# Drainage Letter Report

1830 MAIN STREET  
COLORADO SPRINGS, COLORADO  
80911

December 2, 2019

PPR1938

DETAIL 03 - PROPOSED MICRO-POOL RETROFIT FOR EXISTING EDB OUTLET STRUCTURE
N.T.S.

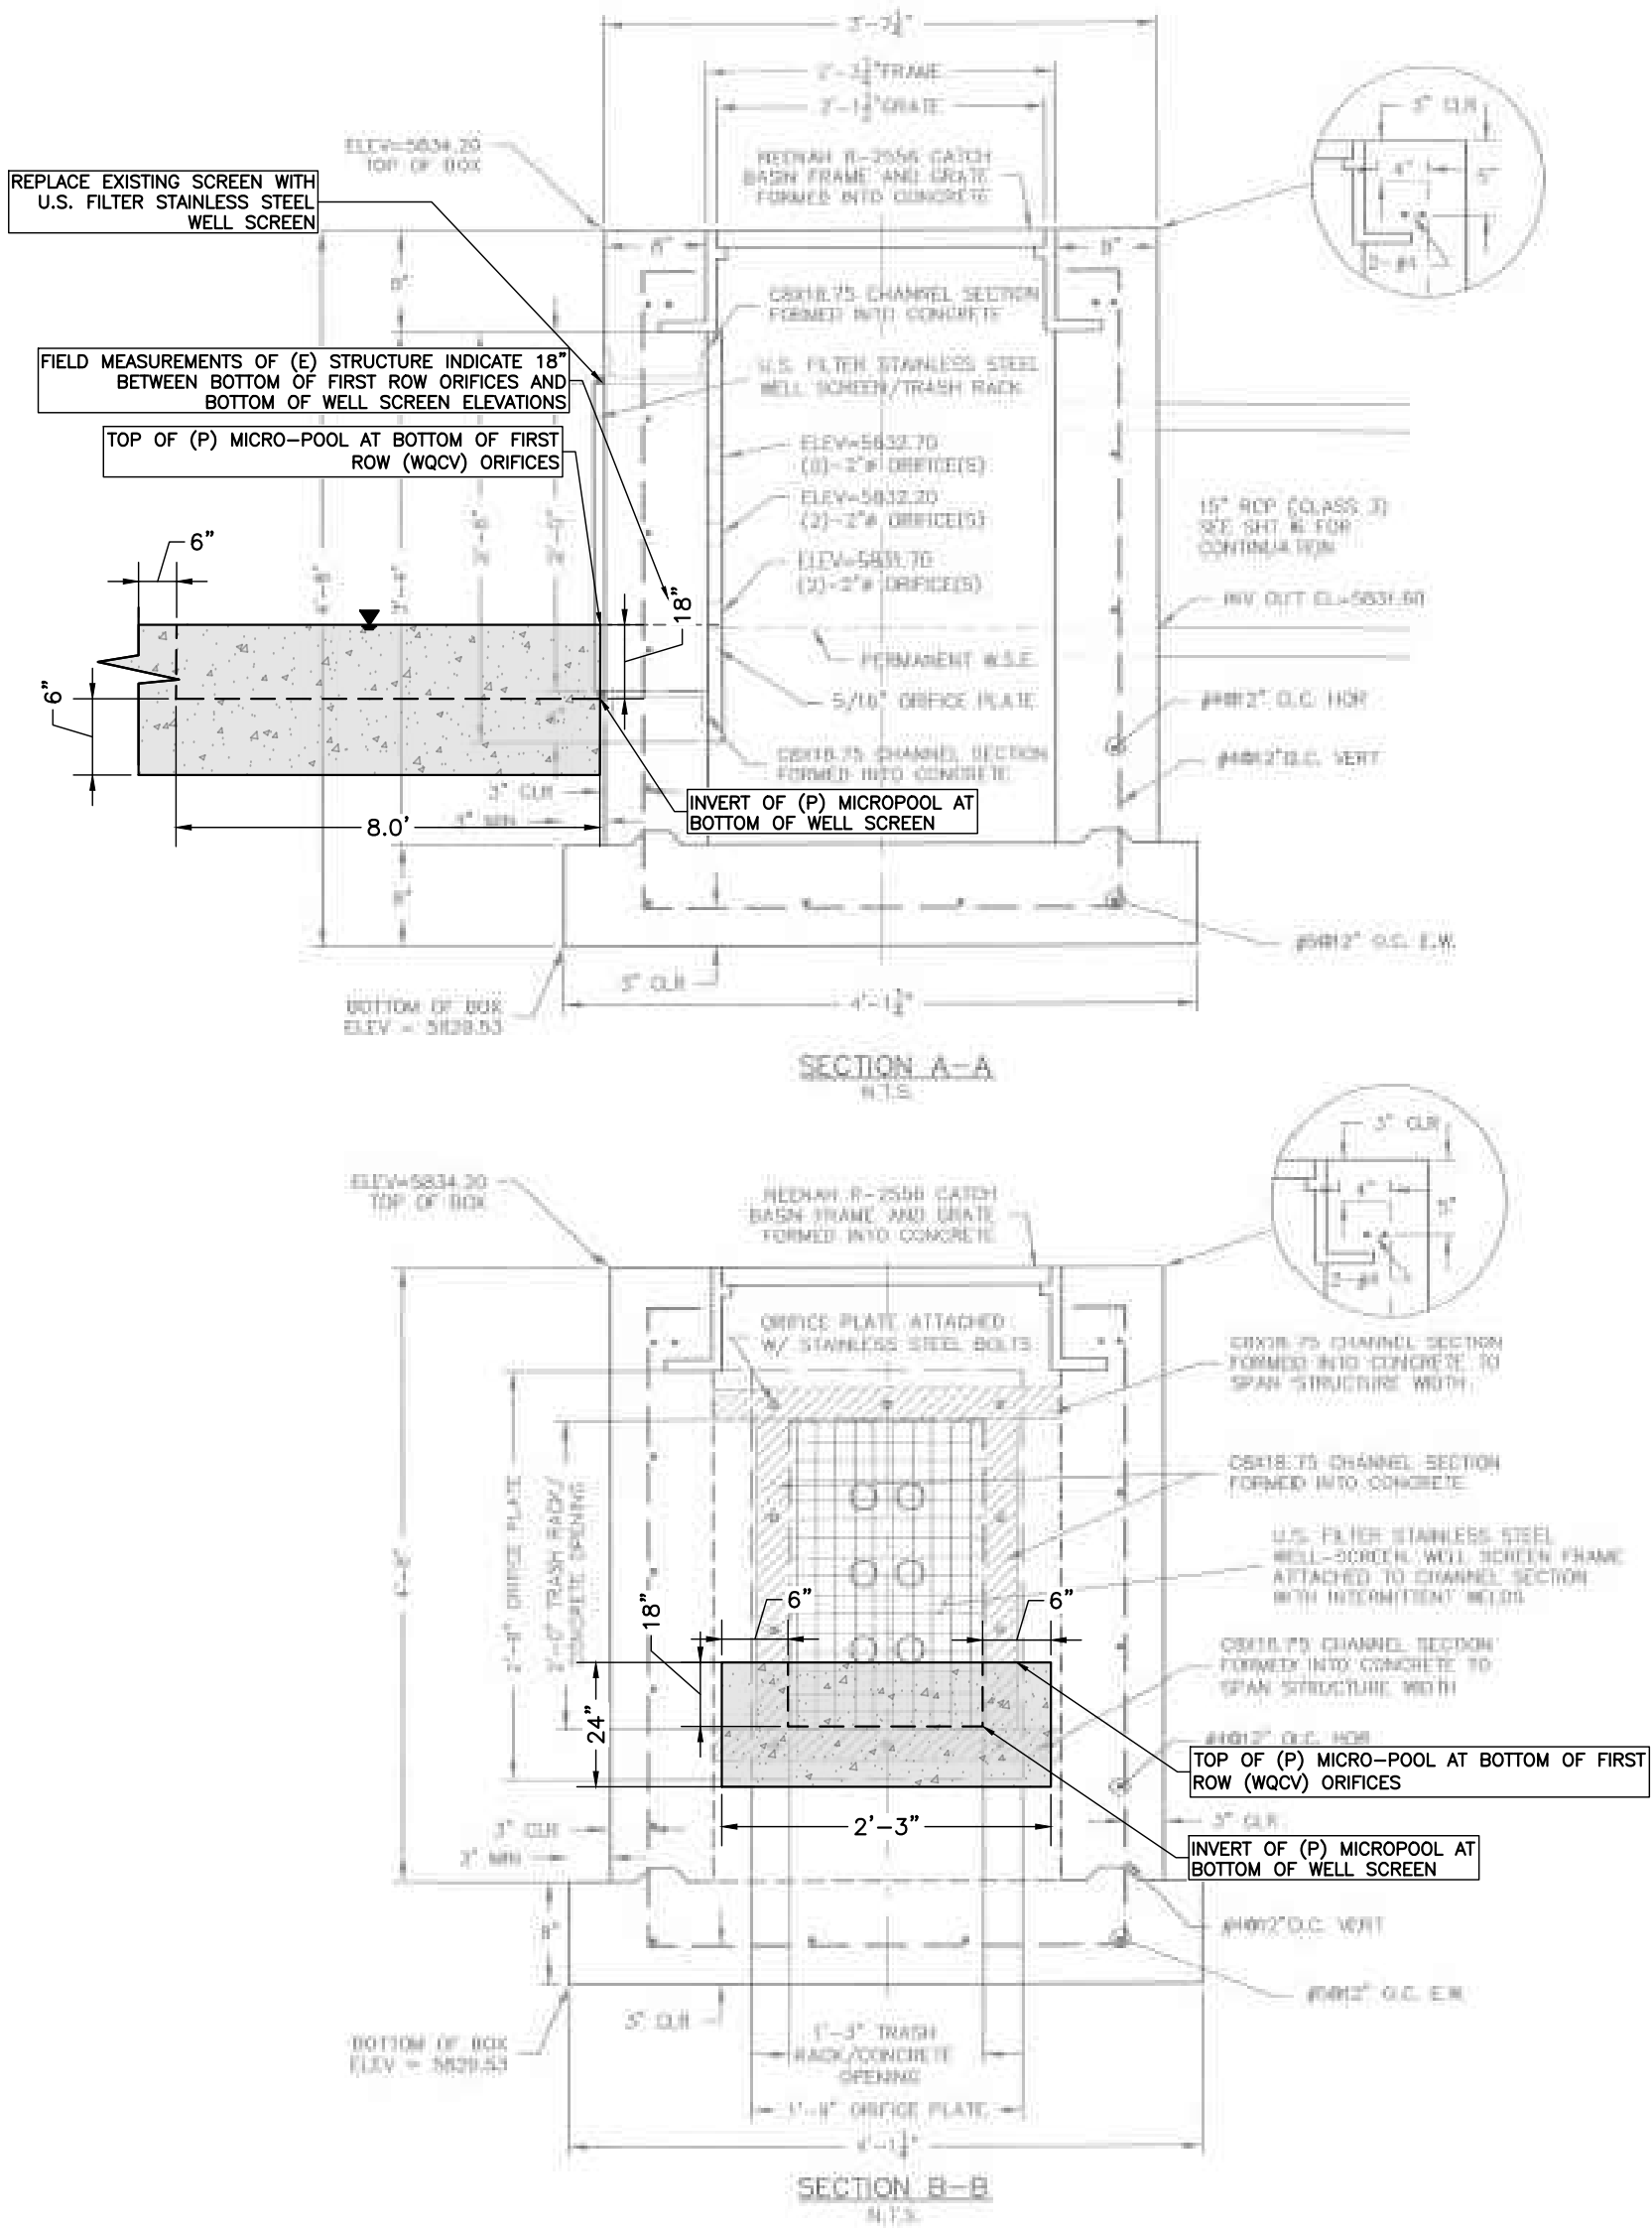
Calculate the SWQCV and FSD volume for this site and show how these volumes are accounted for in the downstream detention facility. Does the downstream facility meet current criteria for SWQCV? does this facility provide the detention required by previous reports and the DBPS?

confirm/state that the existing pond is within today's criteria as well confirm that other lots which drain into the pond have not eaten into the SWQCV and the FSD volume for the existing pond. Or confirm with an overall calculation of existing condition (with allowances for any lots not developed at this time) reference EPC file # SF 07012 in your report and start there please. State that the current pond is functioning as designed or state what work this site should do to get into working order.

Rich, confirm that you are in compliance with the original reports impervious ratio and leave it at that. use the SF07012 report to see what your site was designed for. Please still state that the current pond is functioning as designed or state what work this site should do to get into working order (ie clean outlet structure, i do not know this, i am sending someone out to check??). You will also need to state what size the pipe is that transports your flow to the pond, and state that it is adequate. I believe it was designed and installed with the Townhomes at Bradley, VR104 project.
